Application number: 2026/CLD/91507/E	
What is the application for?:	Certificate of lawfulness for proposed change of use of residential dwelling (Us
Address of the site or building:	12, South Brook Gardens, Mirfield, WF14 8LS
Postcode:	WF14 8LS

SITE PLAN 1:100

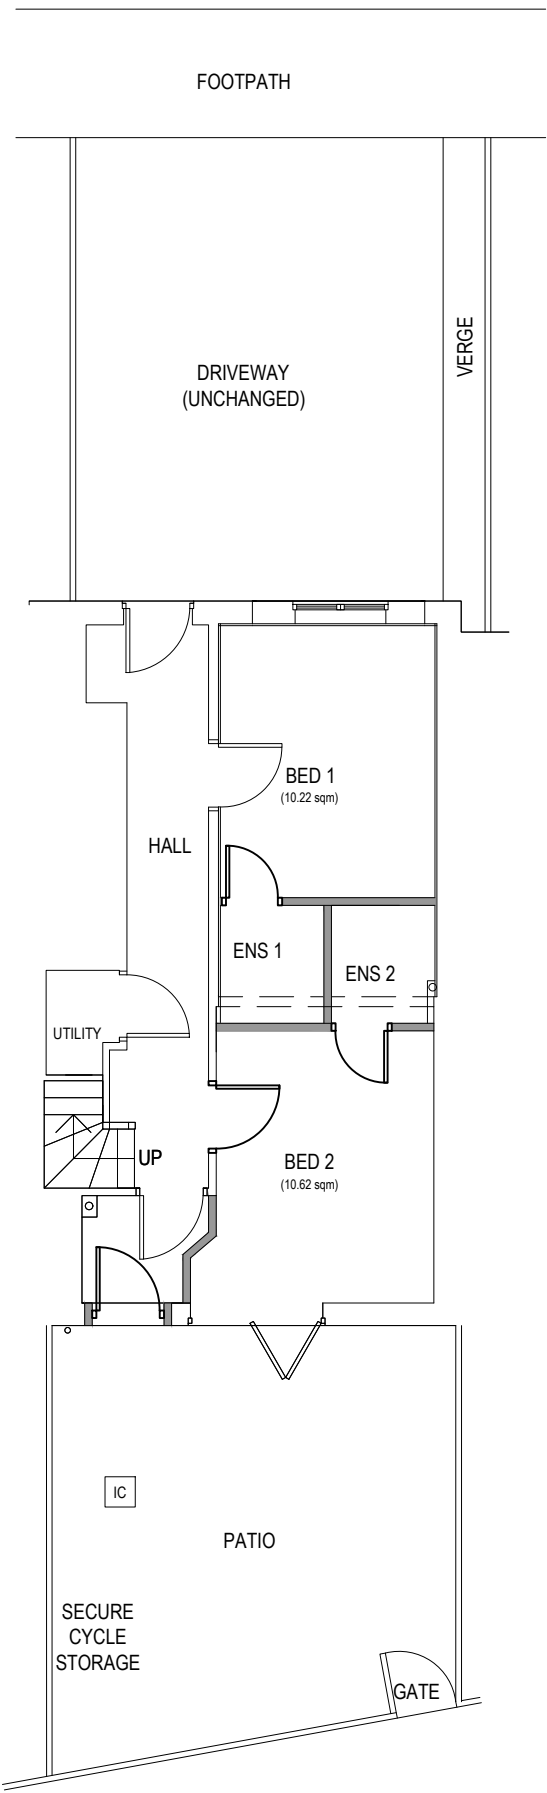
Inadequate Parking and Highway Safety: Our street is already heavily congested with vehicles. A standard family home typically has one or two cars, but an HMO can lead to significantly more vehicles parked on the street. The applicant has not provided enough off-street parking spaces. This will force cars onto pavements, block driveways, and create hazards for pedestrians and emergency vehicles.

Waste Management and Hygiene Issues: An influx of unrelated residents will generate a large volume of domestic waste and recycling. The front of the property lacks the physical space to store the necessary amount of extra bins. This will lead to bins blocking the footway, unsightly litter, and pest issues, which harms the character of the street.
